Major Project Assessment

31st October, 2013

RE: MP 08 0191 Exhibition of Stack Pre-demolition Management Plans

APPENDIX G

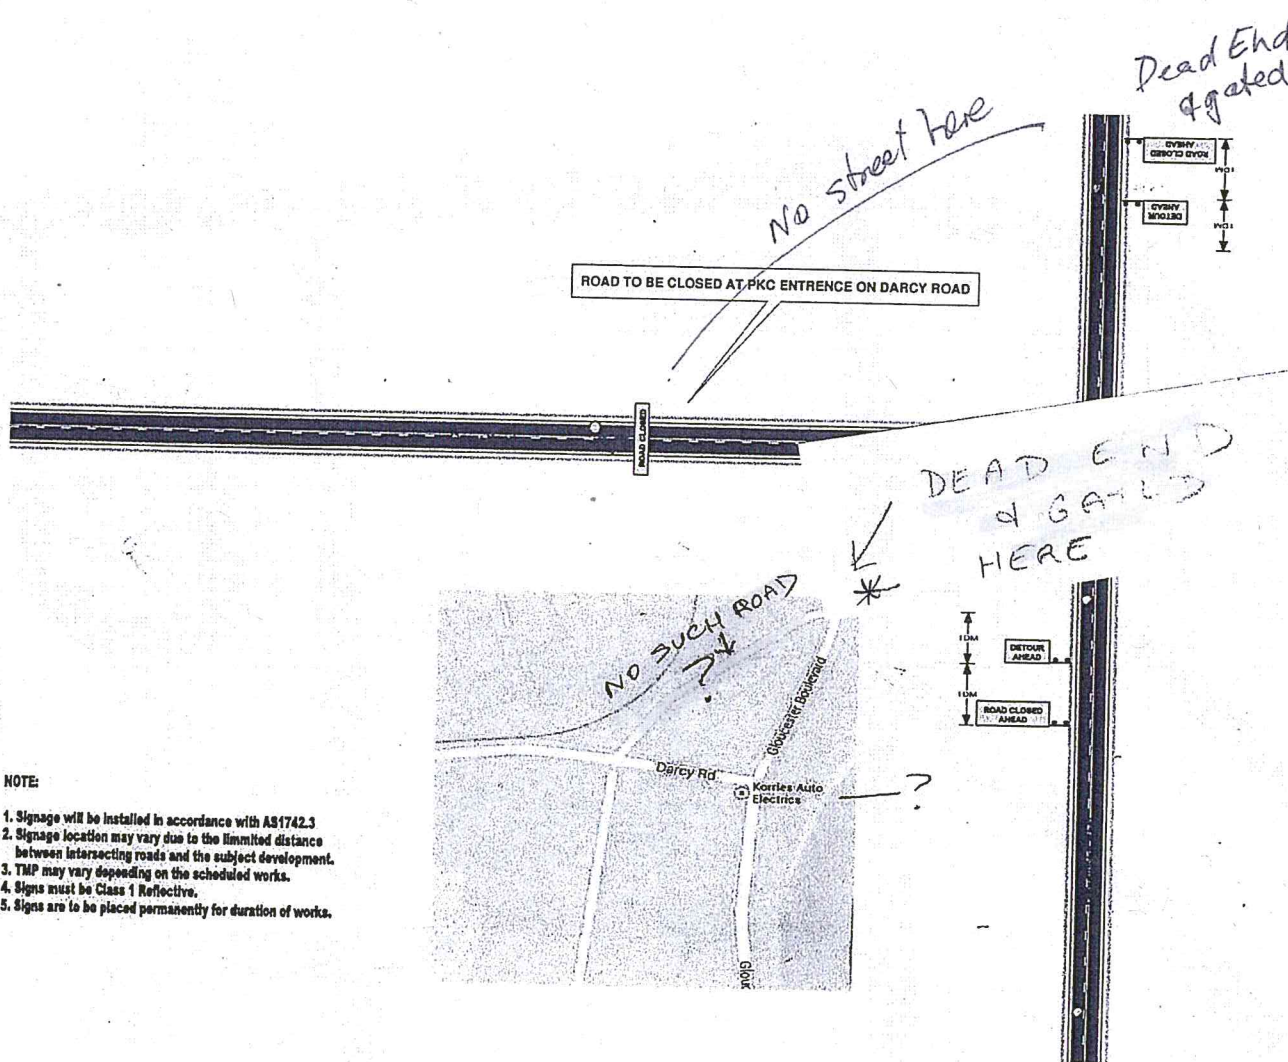
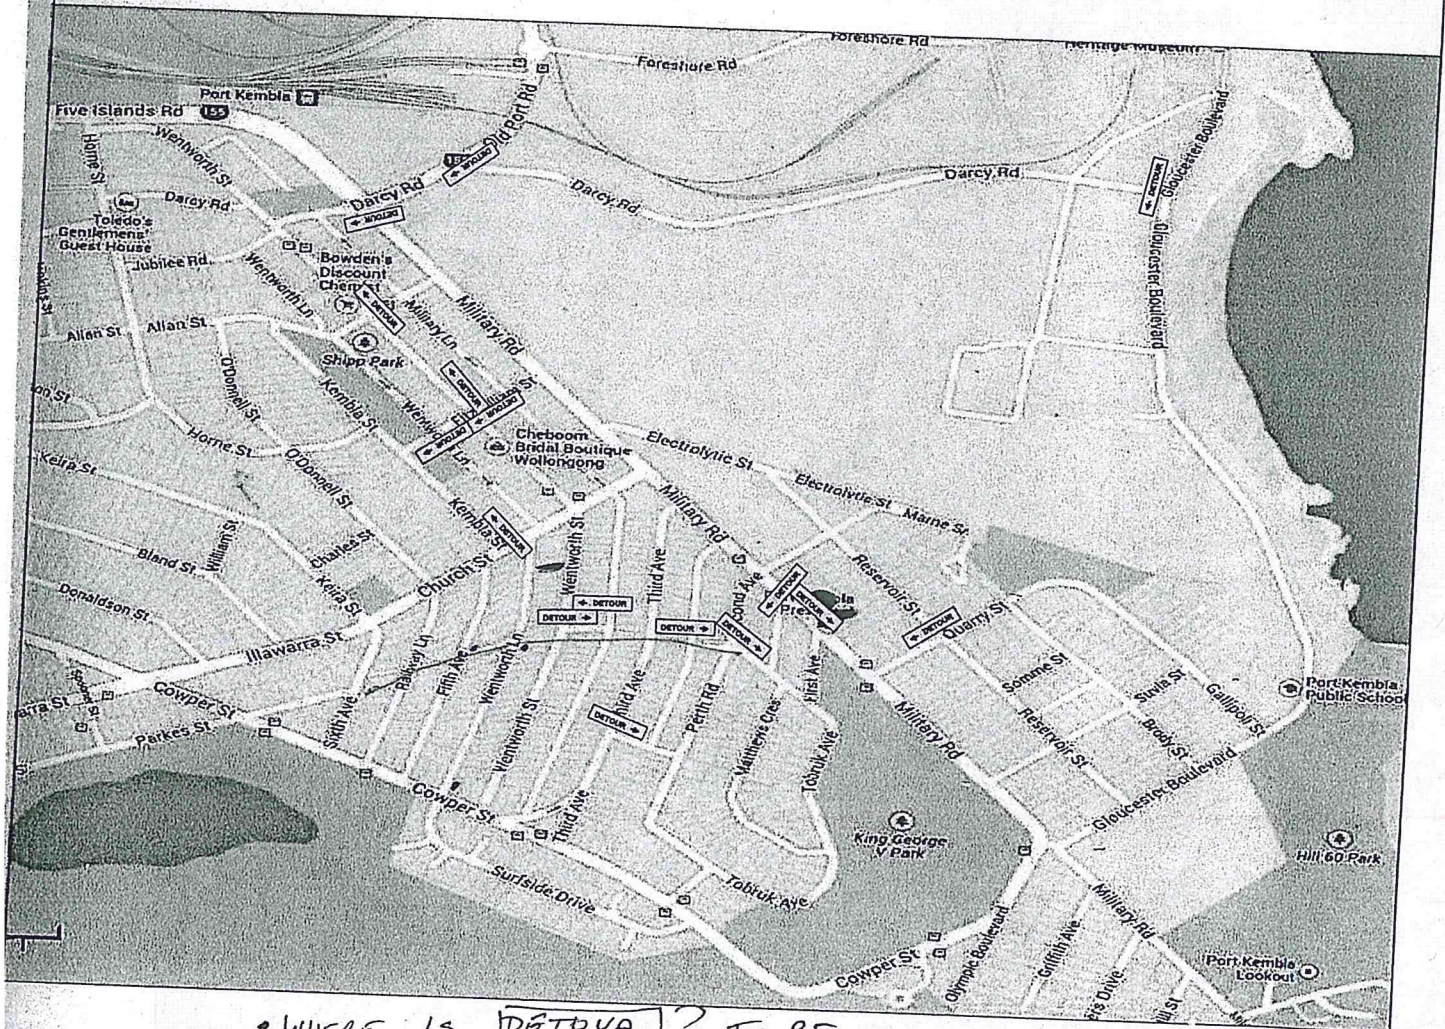
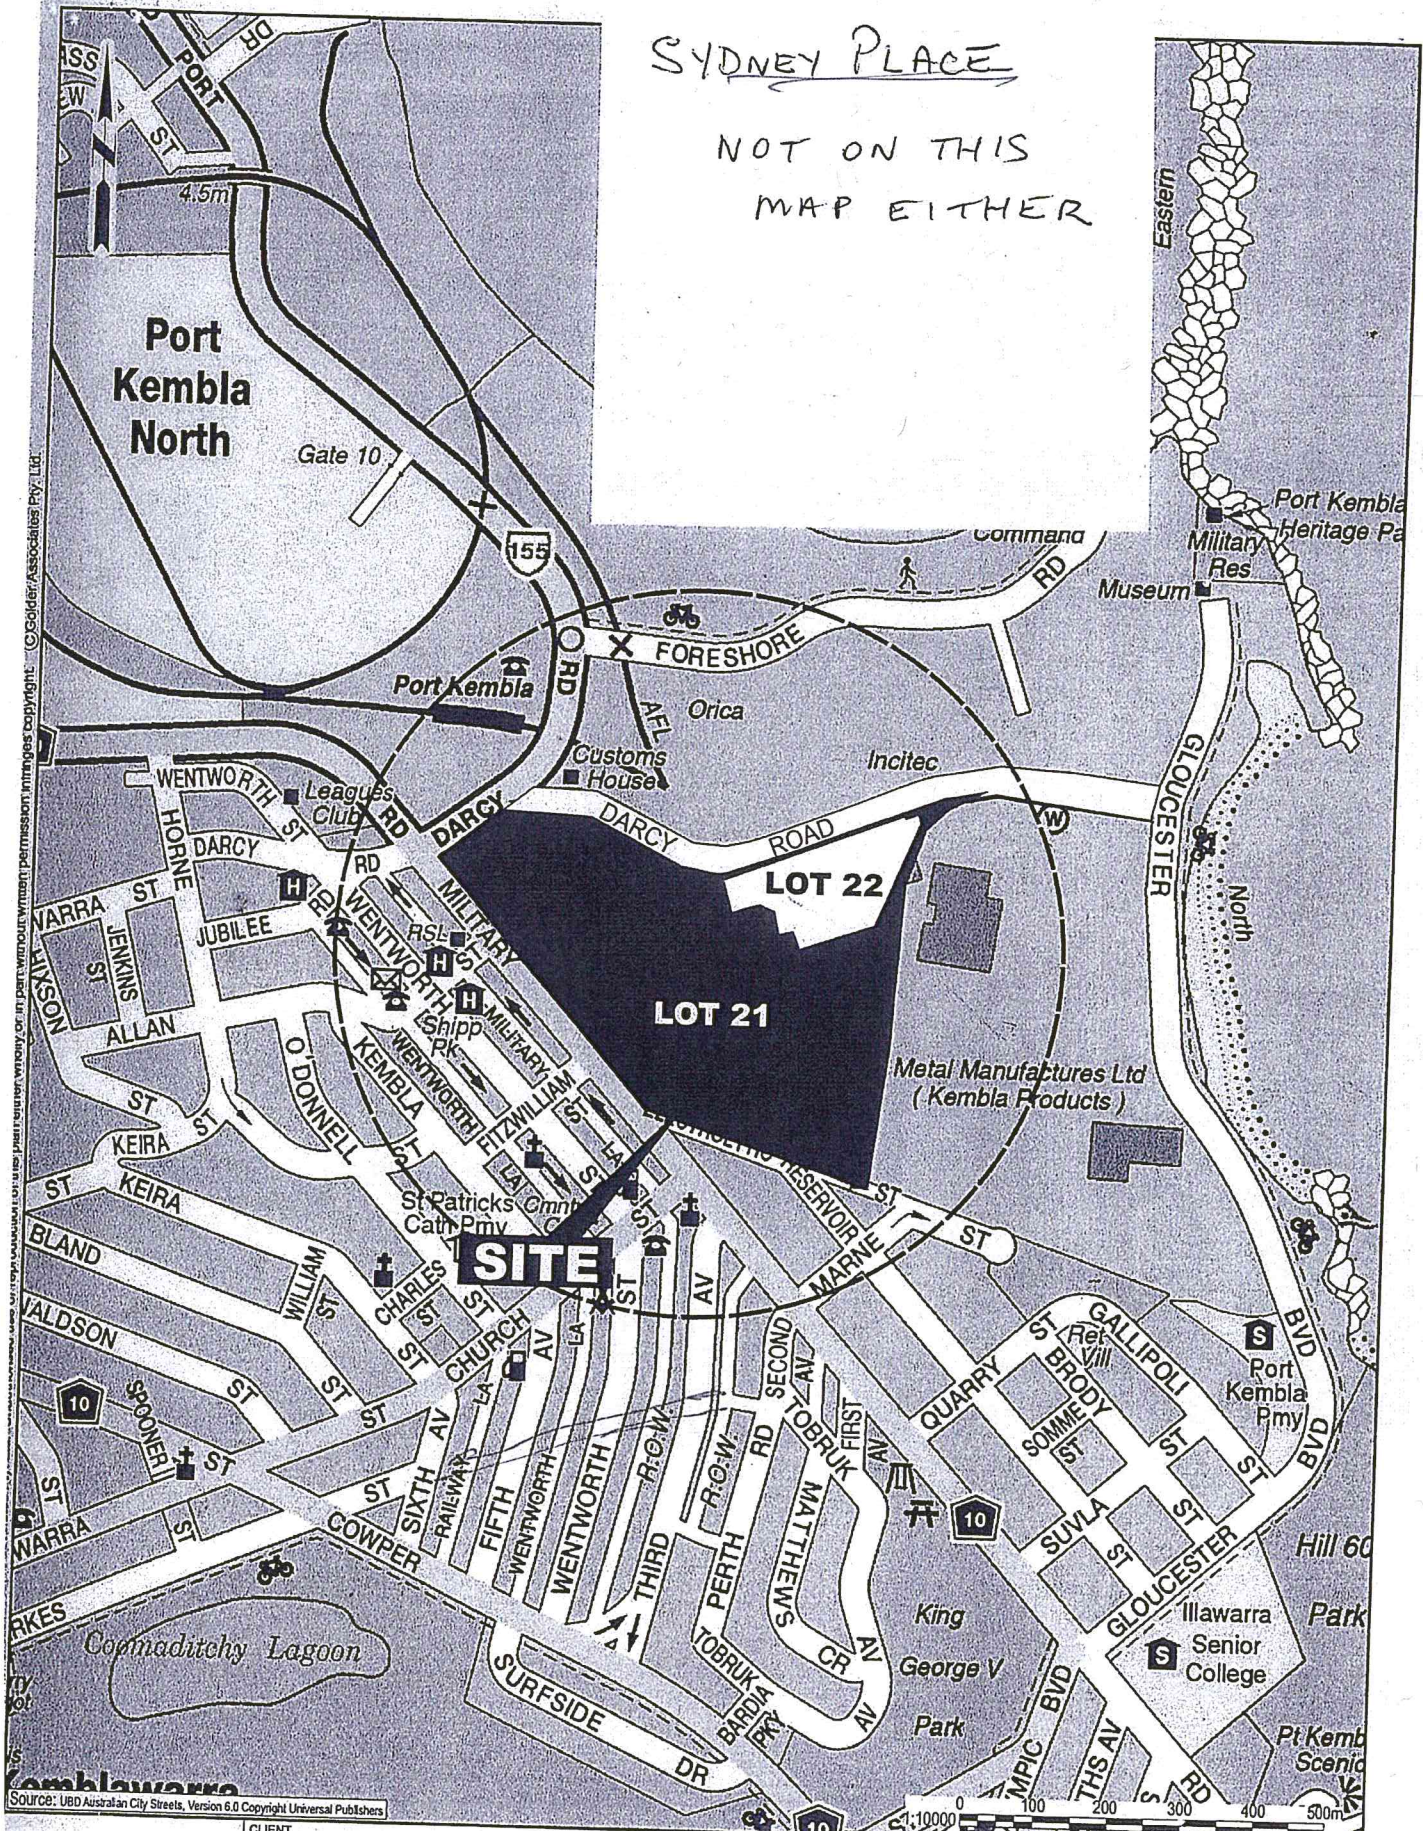
3.2 The maps used in Appendix G in the Golder Plan are wrong. Streets and lanes are missing and sometimes they appear in wrong places.

3.4 A preschool and the Mission for Seamen are wrongly placed on the maps provided.

3.4 Maps in the Golder Plan are illegible.
